Re: Structural Observation — 106 Micahs Way North, Spring Lake, NC 28390

At your request, on January 6, 2025 we performed a review of the structural plan proposed by *Tar Heel Basement Systems* for the first-floor framing stabilization work at the Spring Lake residence noted above. The structure is a conventionally framed, detached, single family residence with raised first floor framing over a pier/girder foundation system with perimeter masonry foundation walls (see *picture 1*).

Picture 2 – Example of haphazard support

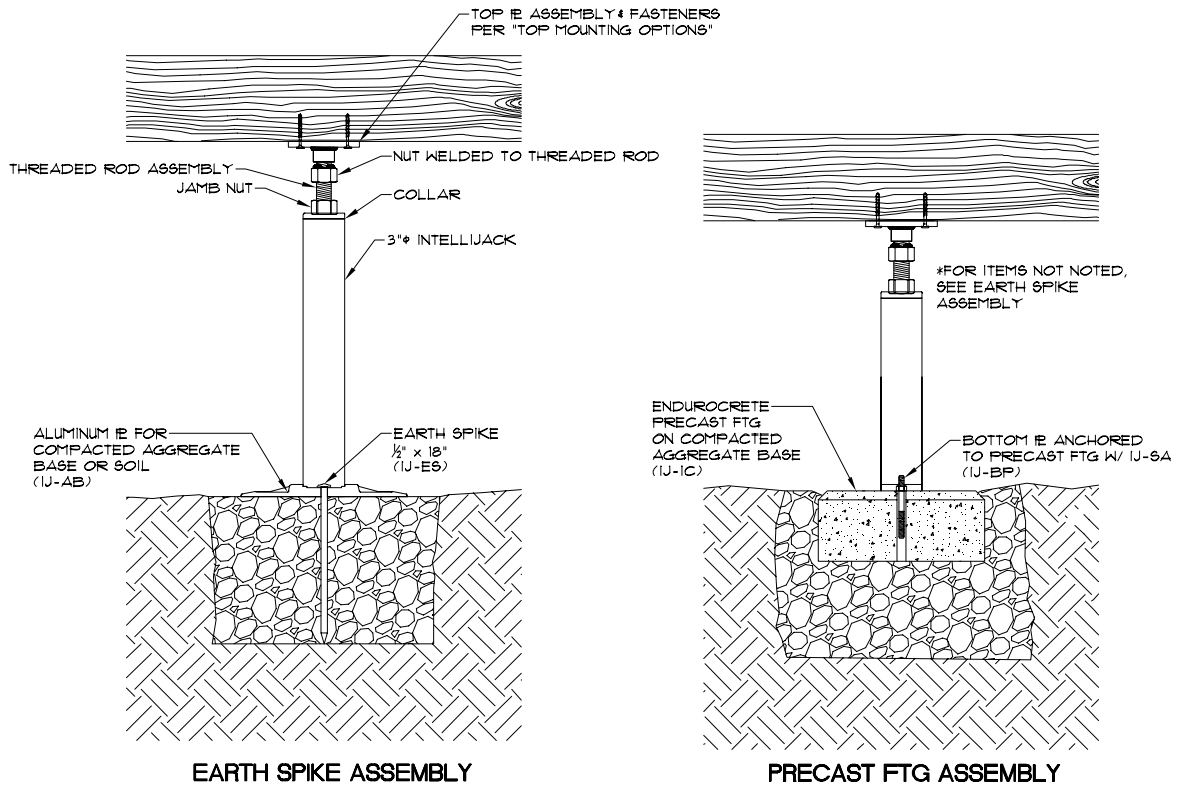
- Between the 2nd and 3rd girder lines from the right, a supplemental dropped girder had been installed. (see *picture 2*).
 - This girder did not appear to be installed to prevent rotation of the girder or appear to have a proper foundation element.

First Floor Framing Stabilization

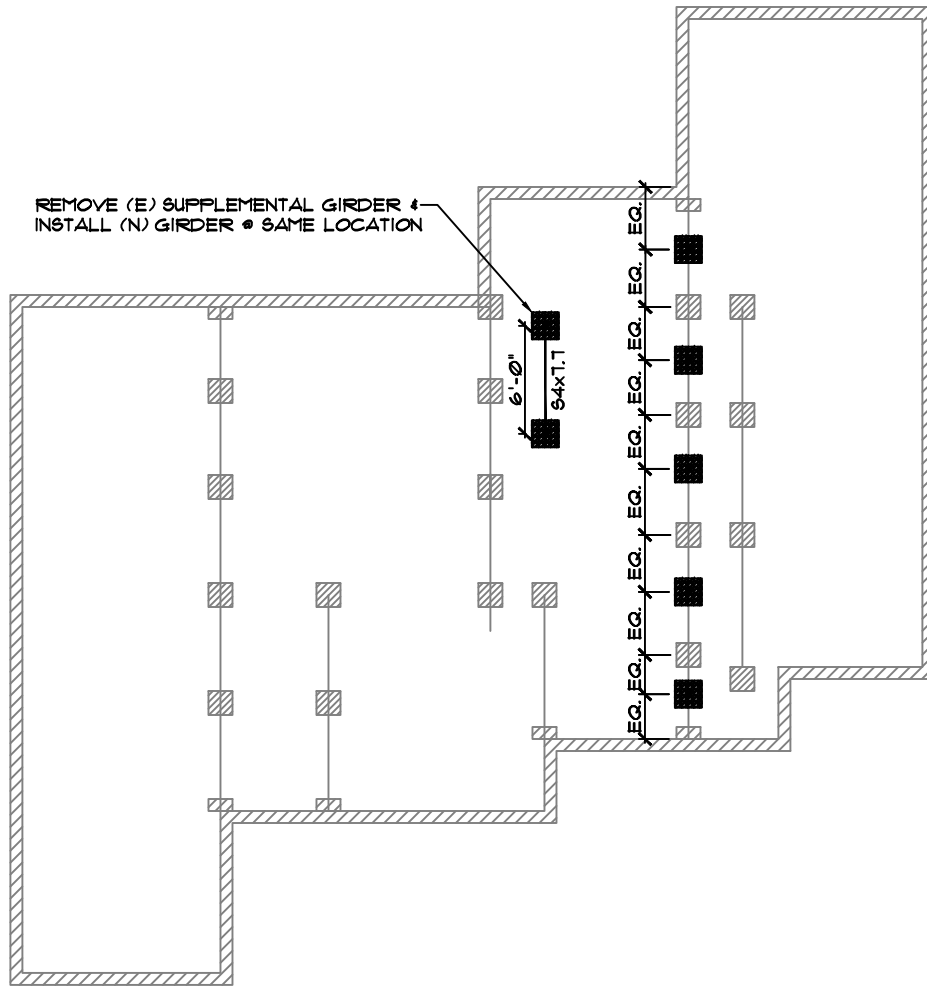
- Uneven floors were reported on the right side of the home in the primary bedroom/bathroom.
 - Measurement by laser level indicated that the 2nd girder line from the right was down as much as approximately ¼" relative to the 3rd girder line from the right. Additionally, this girder was measured to sag as much as approximately ¼" at mid-span between masonry piers.
 - Measurement by laser level indicated that the back end of the second girder line from the right was down by as much as approximately ½" relative to the right foundation wall.

- 1) Reinforce the second girder line from the right foundation wall using an IntelliJack support on a well-compacted 18"x18"x18" gravel footing. Jacks should be located within the middle 1/3 of each girder span and at the approximate locations shown in the attached repair schematic (*see detail 1*).
- 2) Replace the above noted supplemental girder with a new S4x7.7 dropped girder within the middle 1/3 of the joist span. Support the replacement girder using IntelliJack supports on well-compacted 18"x18"x18" gravel footings spaced no more than 6'-6" apart (*see detail 1*).
